# CITY OF ALBUQUERQUE

November 18, 2019

**Re: Kramer Basketball Complex**  
**2811 Karsten CT SE Albuquerque NM**  
**Traffic Circulation Layout**  
Engineer's/Architect's Stamp 11-11-2019 (M14D012I)

AS-1.0

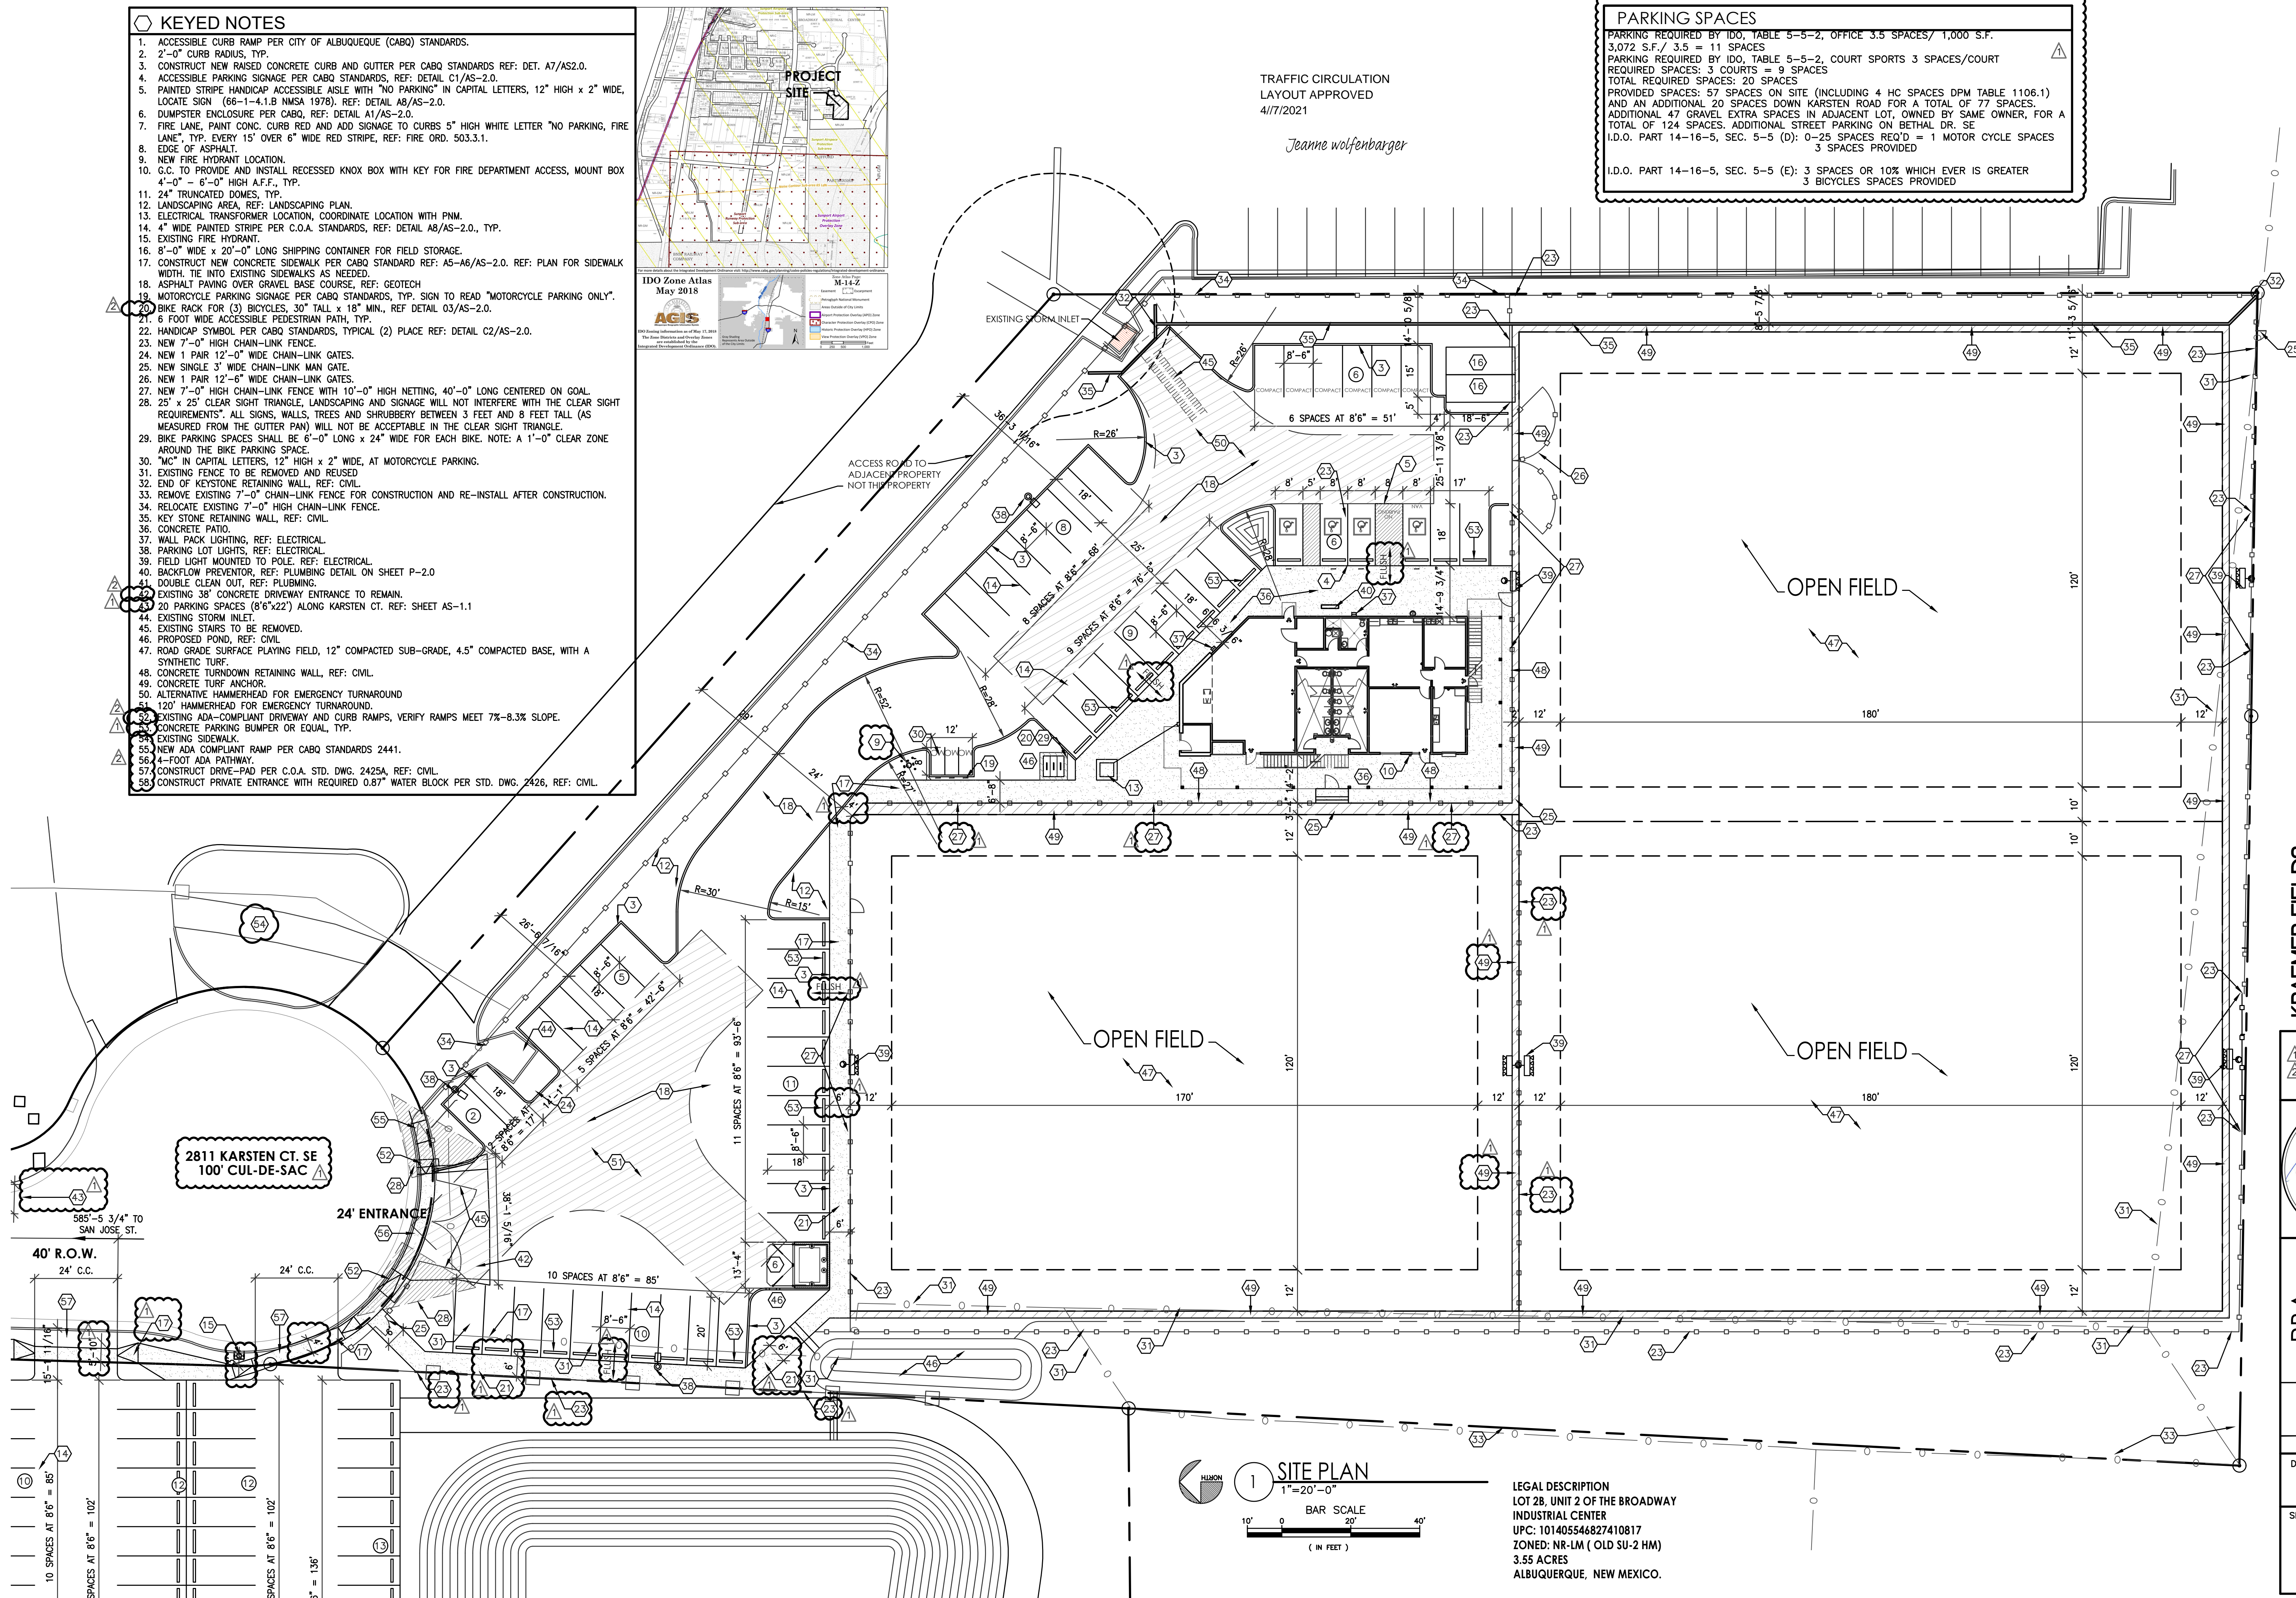
1. Label the compact parking spaces by placing the words "**COMPACT**" on the pavement of each space.
2. The ADA access aisles shall have the words "**NO PARKING**" in capital letters, each of which shall be at least one foot high and at least two inches wide, placed at the rear of the parking space so as to be close to where an adjacent vehicle's rear tire would be placed. (66-1-4.1.B NMSA 1978)

3. All bicycle racks shall be designed according to the following guidelines:
  - a. The rack shall be a minimum 30 inches tall and 18 inches wide.
  - b. The bicycle frame shall be supported horizontally at two or more places. Comb/toaster racks are not allowed.

- c. The rack shall be designed to support the bicycle in an upright position. See the IDO for additional information.
  - d. The rack allows varying bicycle frame sizes and styles to be attached.

- e. The user is not required to lift the bicycle onto the bicycle rack.
  - f. Each bicycle parking space is accessible without moving another bicycle.

4. Bicycle racks shall be sturdy and anchored to a concrete pad.
5. A 1-foot clear zone around the bicycle parking stall shall be provided.
6. Bicycle parking spaces shall be at least 6 feet long and 2 feet wide.

7. ADA accessible pedestrian pathway should not be placed behind parking space or adjacent to a vehicular way. Vehicle and pedestrian/wheel chair conflicts should be avoided as much as possible.

8. Refuse vehicle maneuvering shall be contained on-site. The refuse vehicle shall not back into the public right of way.; **provide a copy of refuse approval.**

9. Remove the fire line from TCL. No red striping behind the parking spaces.
